PLANNING CONSULTATION RESPONSE

Application No	2026/0409 & 0410
Proposal	2026 0409 & 0410 (PP & LBC) Internal & External Alterations Part Retrospective 33 Darton Road Cawthorne
Address	33 Darton Road Cawthorne
Date of Consultation Reply	280726
Consultee	Tony Wiles Senior Conservation Officer

Ref **33 Darton Road Cawthorne**

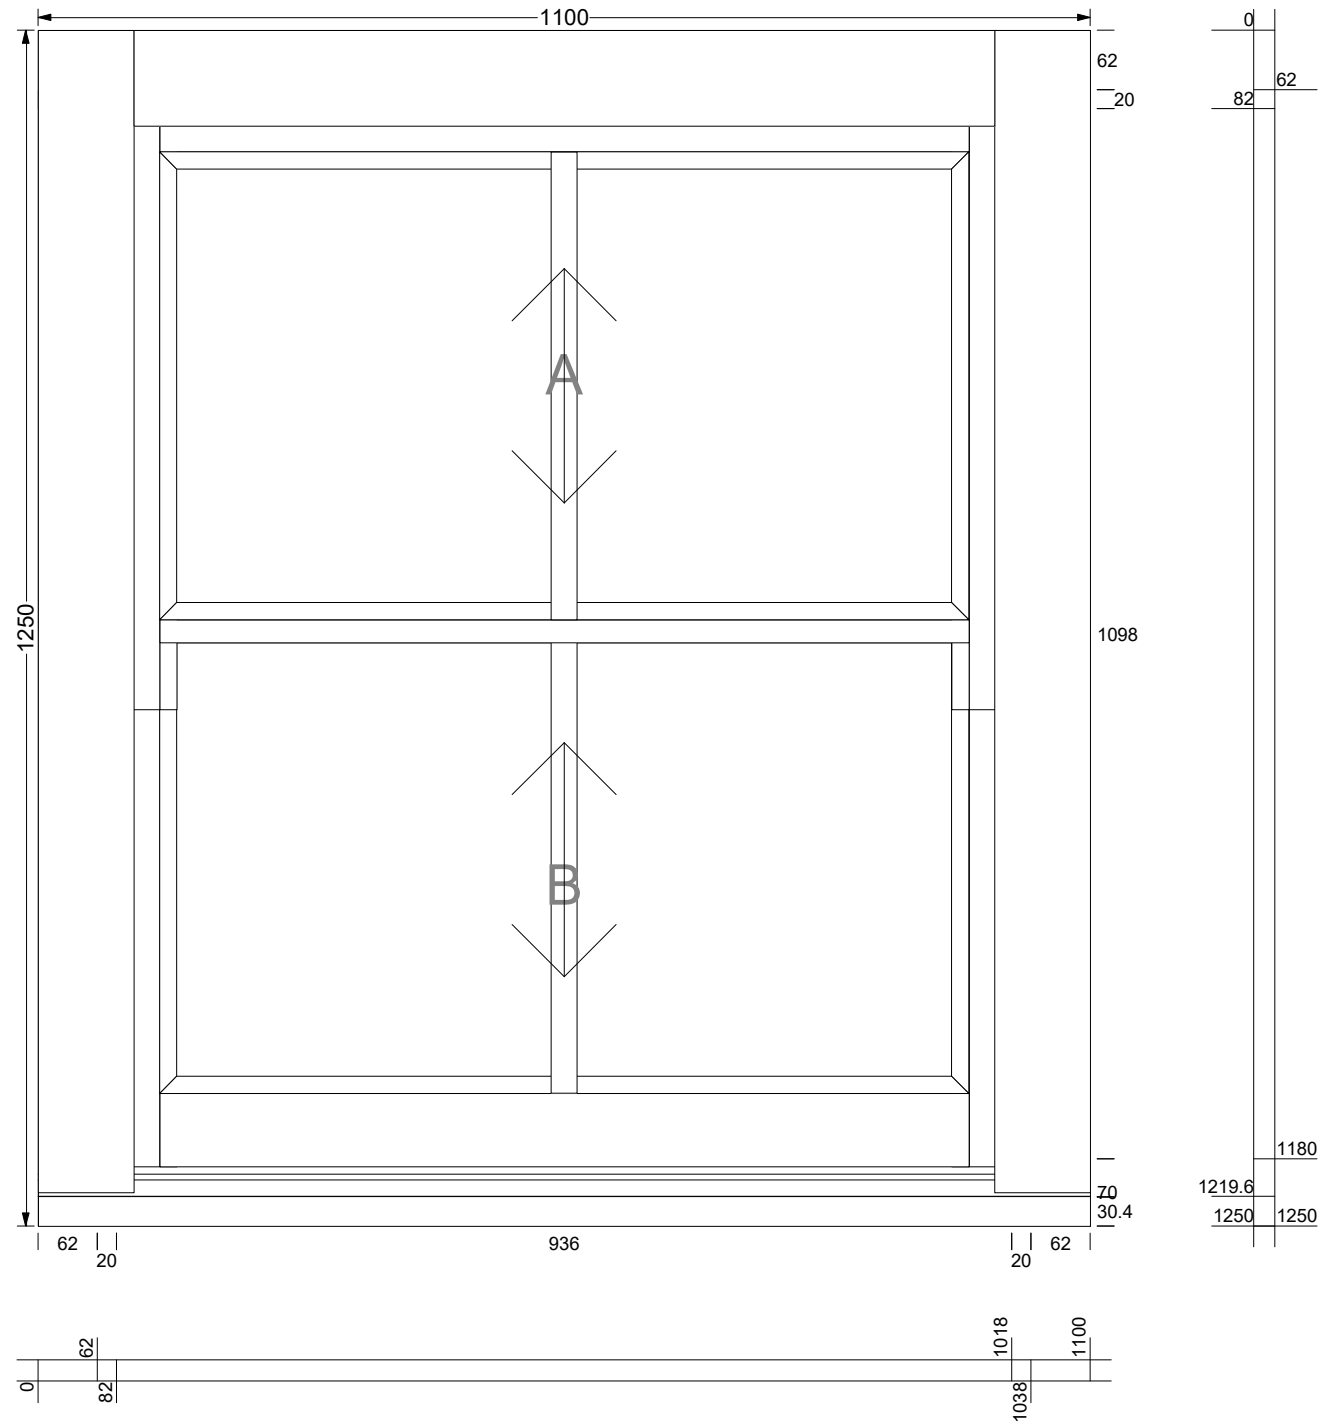
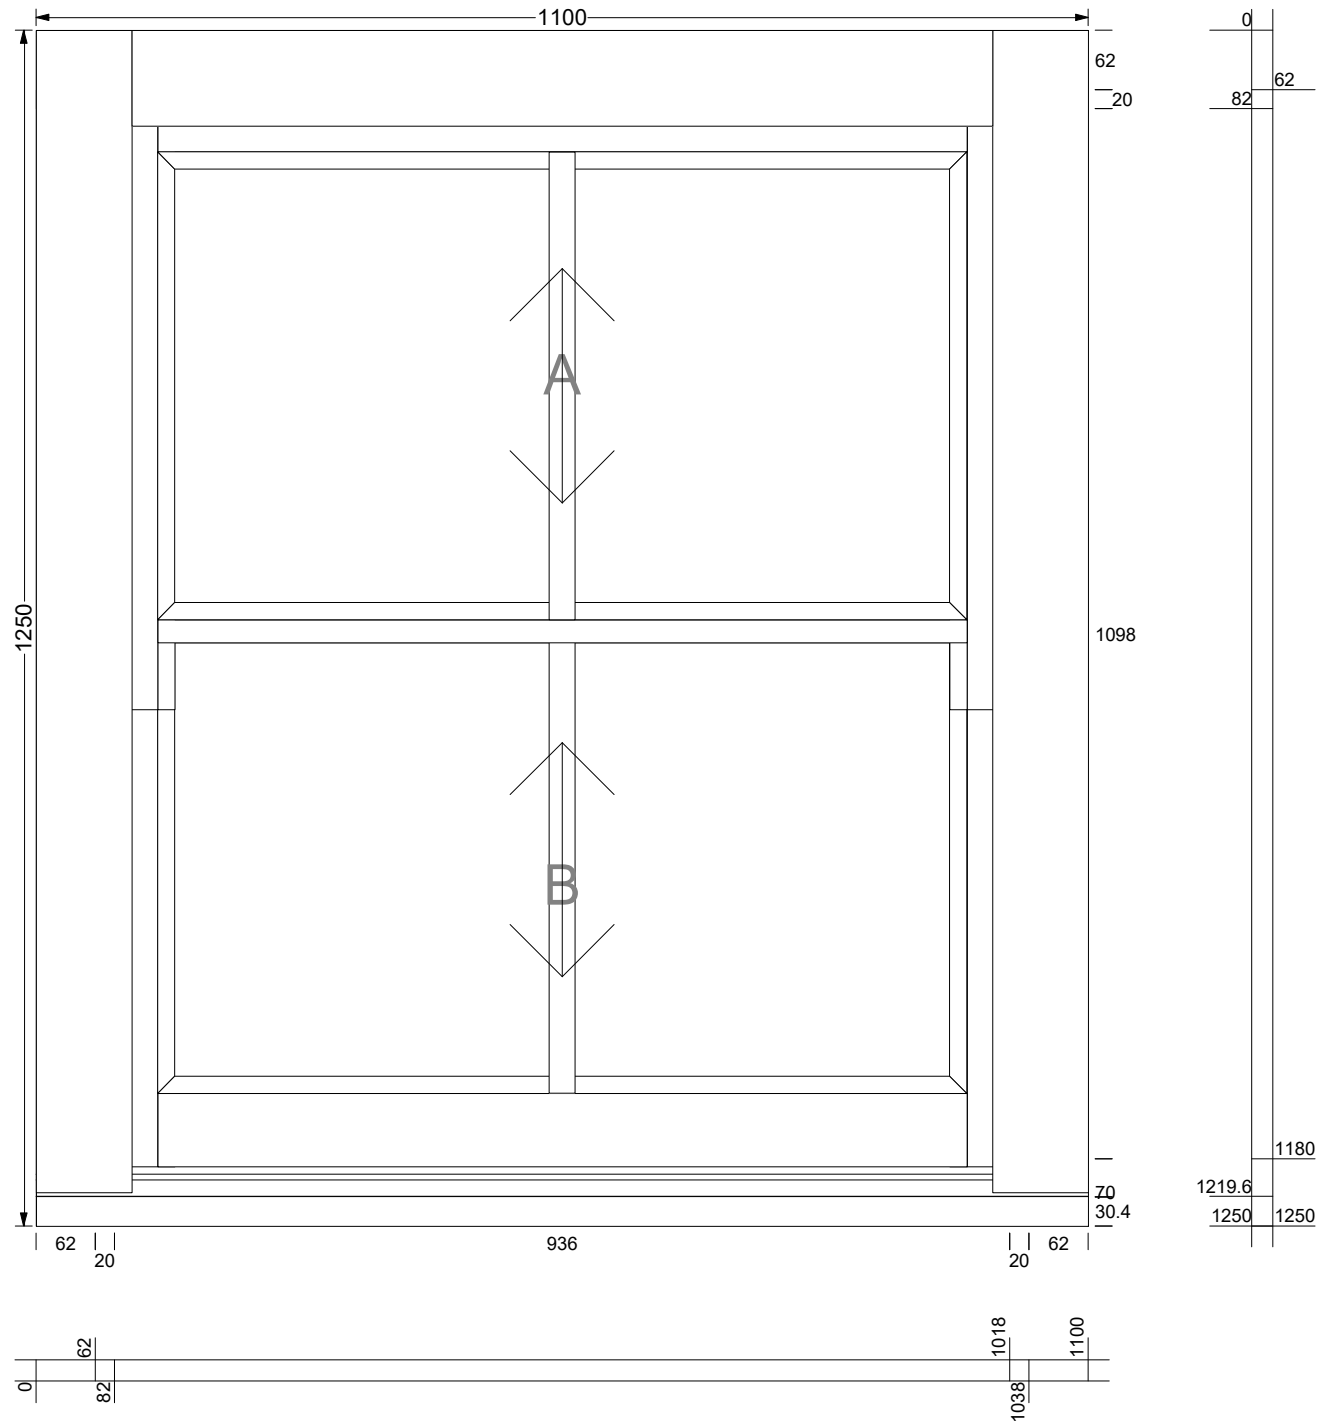
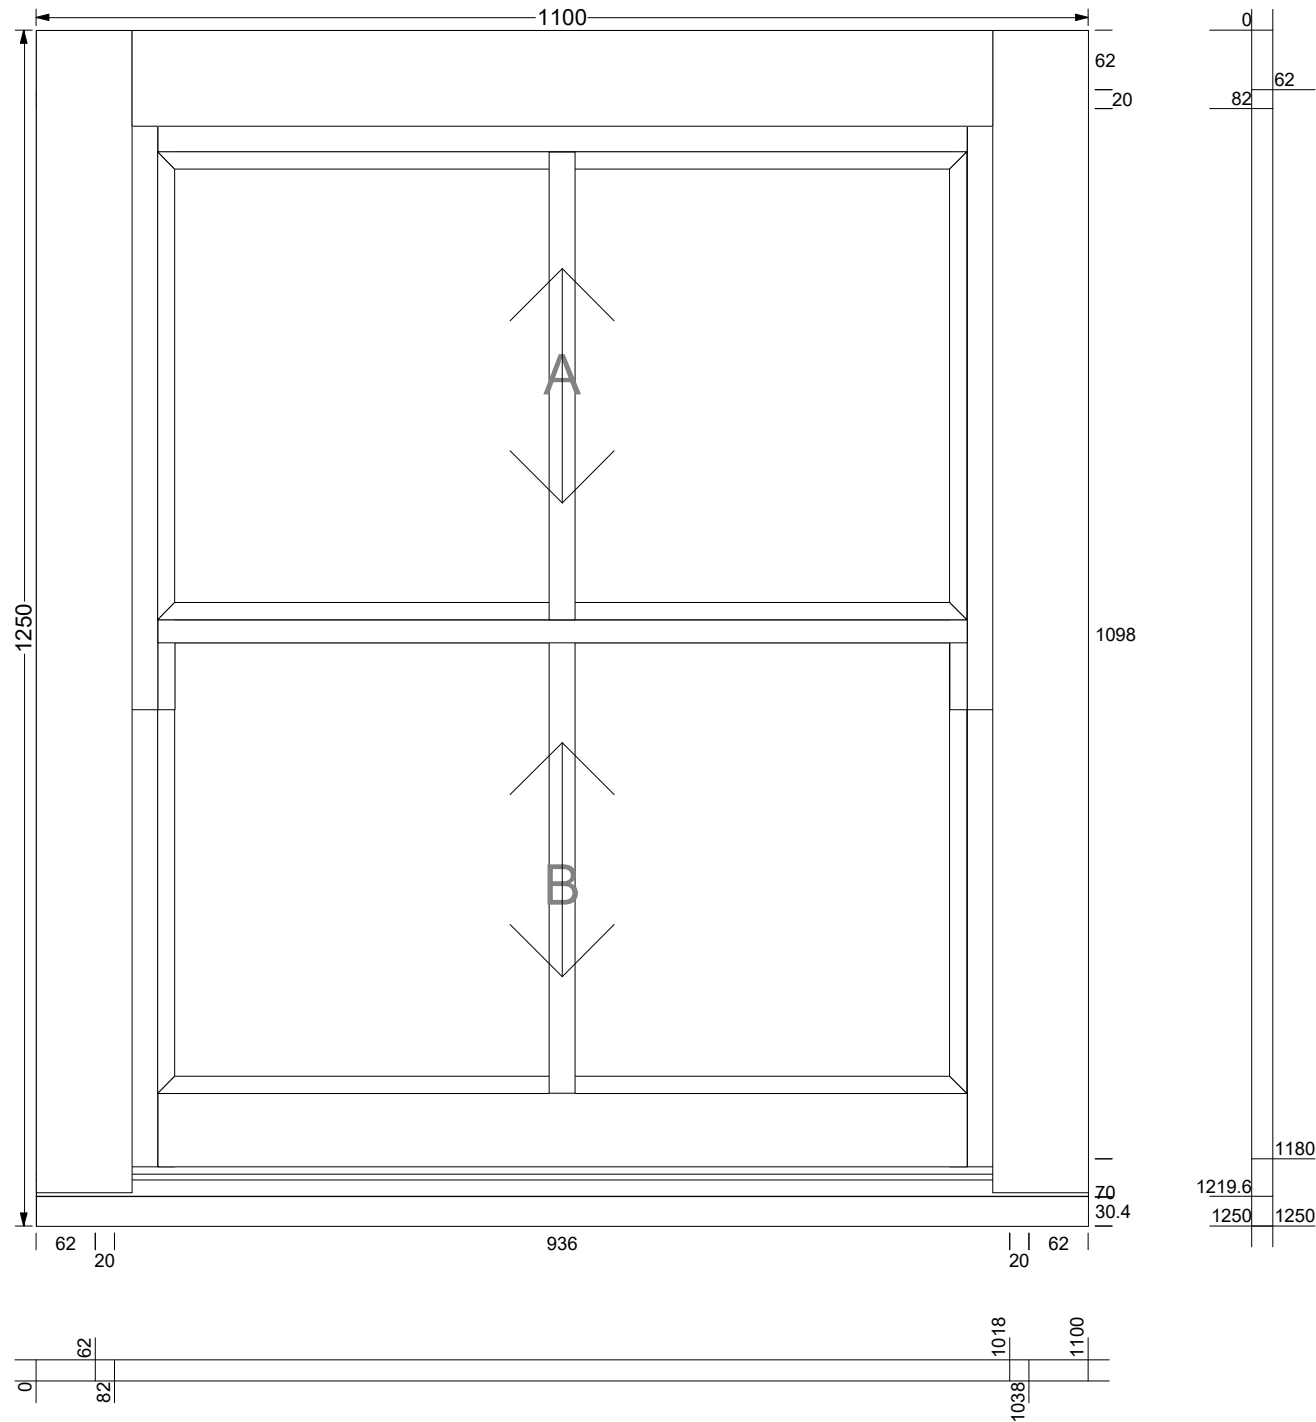
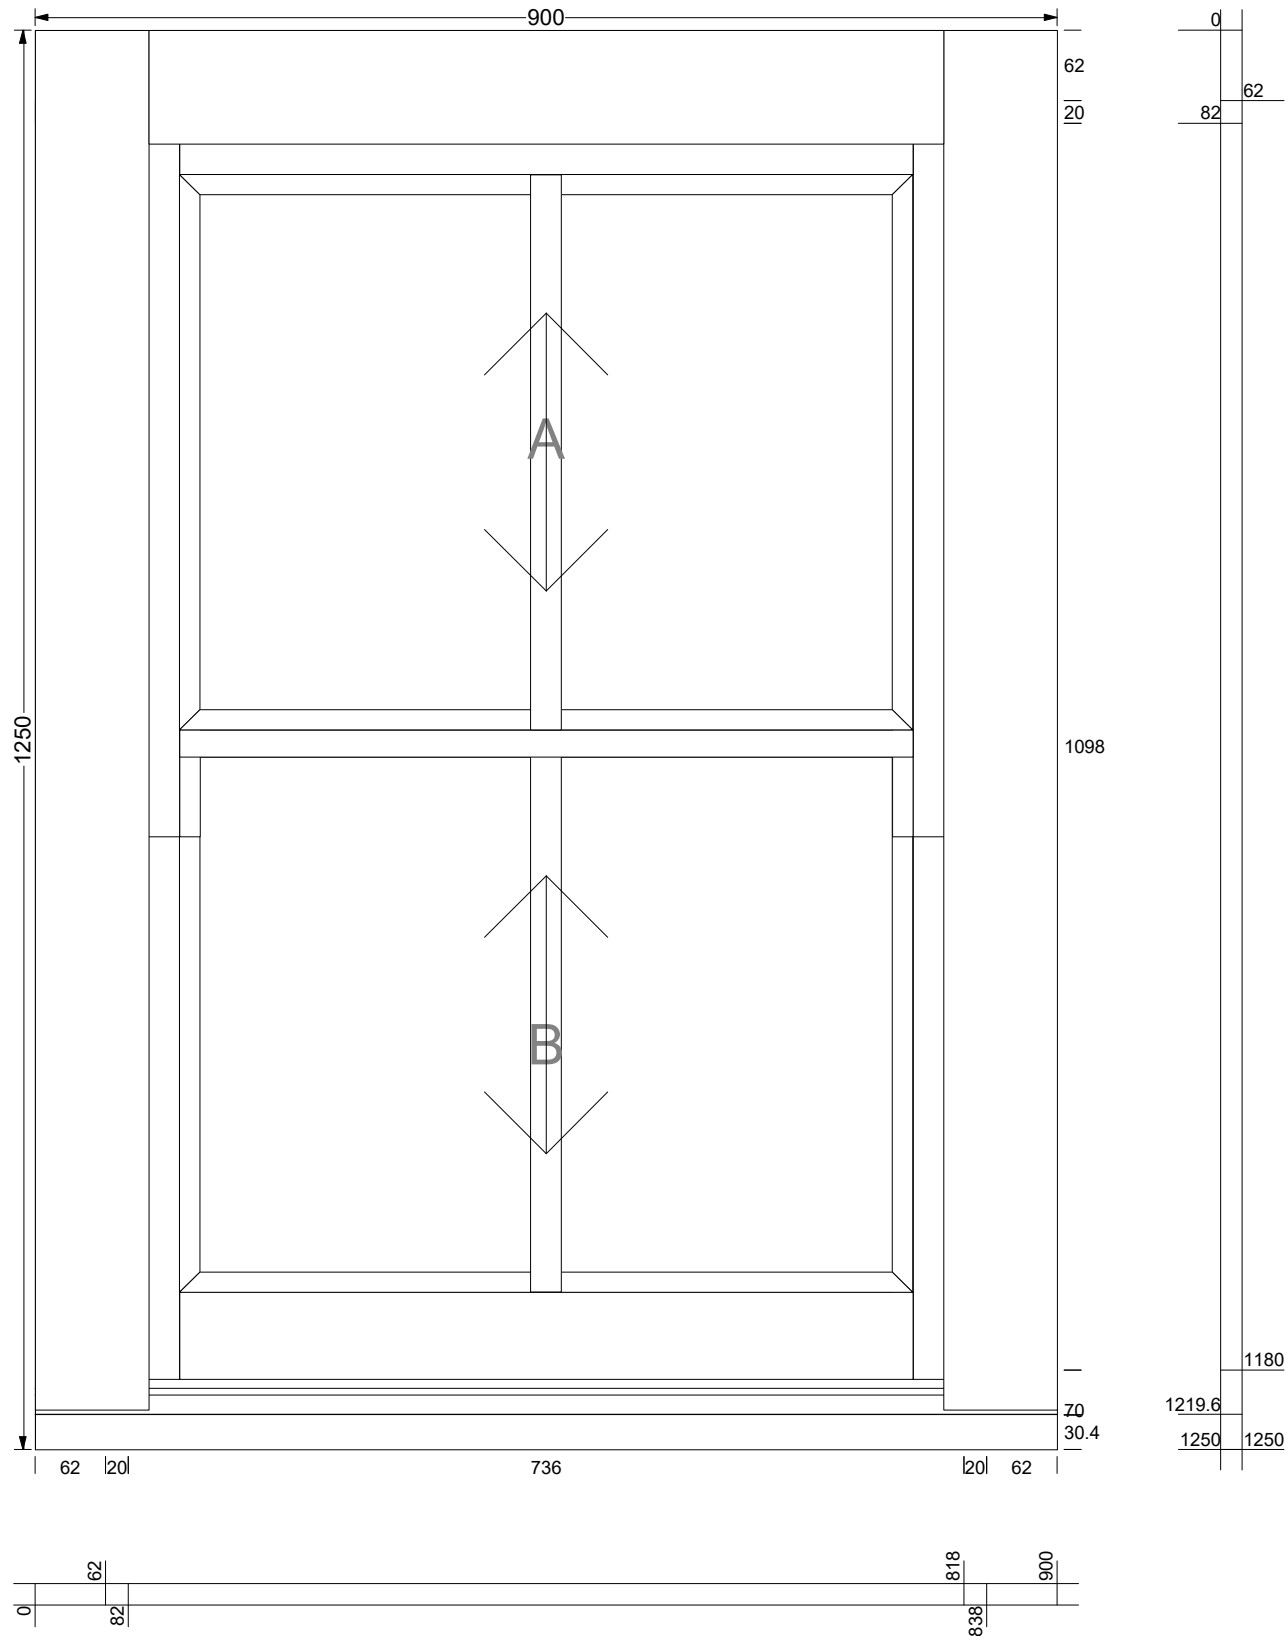
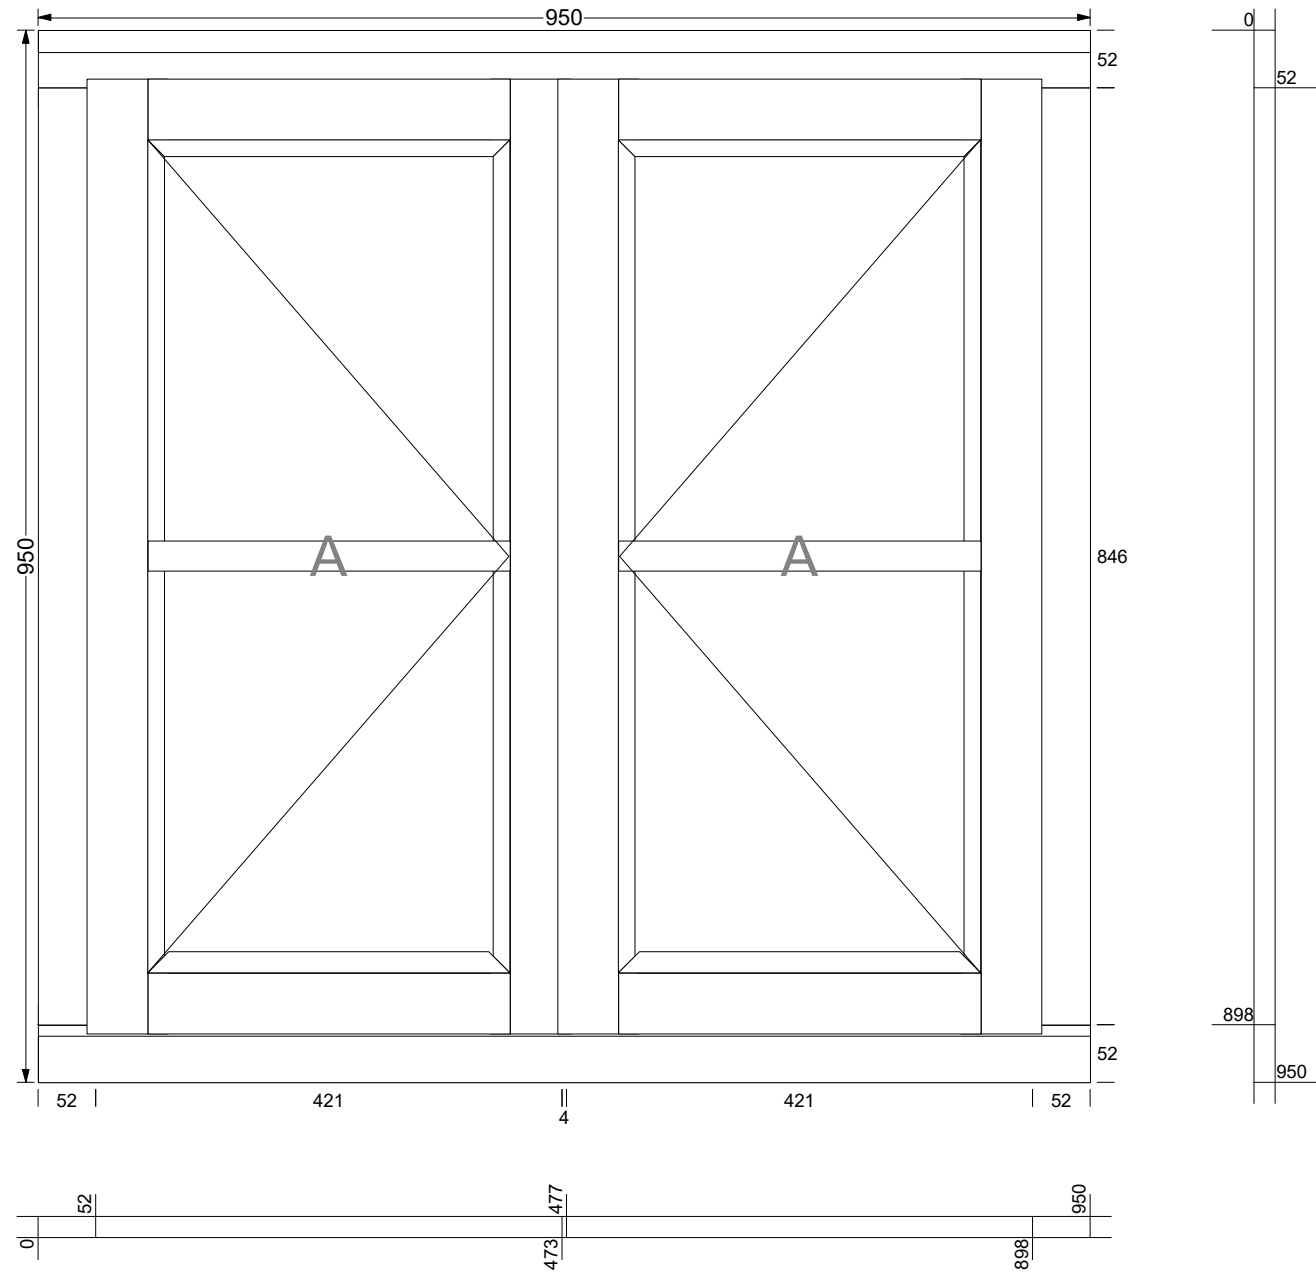
The works include a number of matters that may reasonably be regarded as repair, having been undertaken on a like-for-like basis. For example, the roof has been fully repaired using stone roofing slates and the rainwater goods have been renewed with sympathetic materials. The submitted plans indicate the renewal of all rainwater pipes and soil pipes in Alumasc Heritage. Some areas of perished stone, notably to the roadside frontage, have also been replaced with matching stone and repointed. These areas are not shown on the plans, although the area to the rear, around the modern underpinning, is detailed and this work has already been completed. I have no concerns with these elements. Discussions took place with the applicant some months ago regarding the nature and detail of the works already carried out. However, the submitted plans also include additional new works that merit further consideration. These principally comprise the replacement doors and windows, together with internal alterations at ground and first-floor level. The existing windows are modern and vary in design, fixtures and furniture, none of which appear to be original. On that basis, I would not object to their replacement in timber as generally indicated, although the submitted information is somewhat limited in detail. Ideally, representative window and door elevations at 1:20 or 1:10, together with 1:5 cross-sections, would provide an appropriate level of detail. I have included a draft condition below to address this point. However, following discussion with the applicant, this may not be necessary if amended plans or sufficiently detailed manufacturer's information for the proposed windows and doors is submitted.

- All new stonework shall match the existing and utilise natural sandstone with matching course heights, face dressing and overall appearance.
- All replacement windows and doors shall be constructed in timber. Full details of their design, construction and finish (including details of heads and cills, means of opening and glazing pattern) shall be submitted to and approved in writing by the local planning authority before the commencement of the relevant site works. The details shall include an elevation at 1:20 or 1:10 scale of each door or window type and 1:5 scale cross-sections. Development shall be carried out in accordance with the approved details. * **Note this may not be required if we receive adequately detailed and updated plans.**

- All new windows and doors shall be mounted a minimum of 100mm in the reveal.
- All rainwater goods and soil pipes shall be in aluminium (Alumasc Heritage or similar) and decorated black.
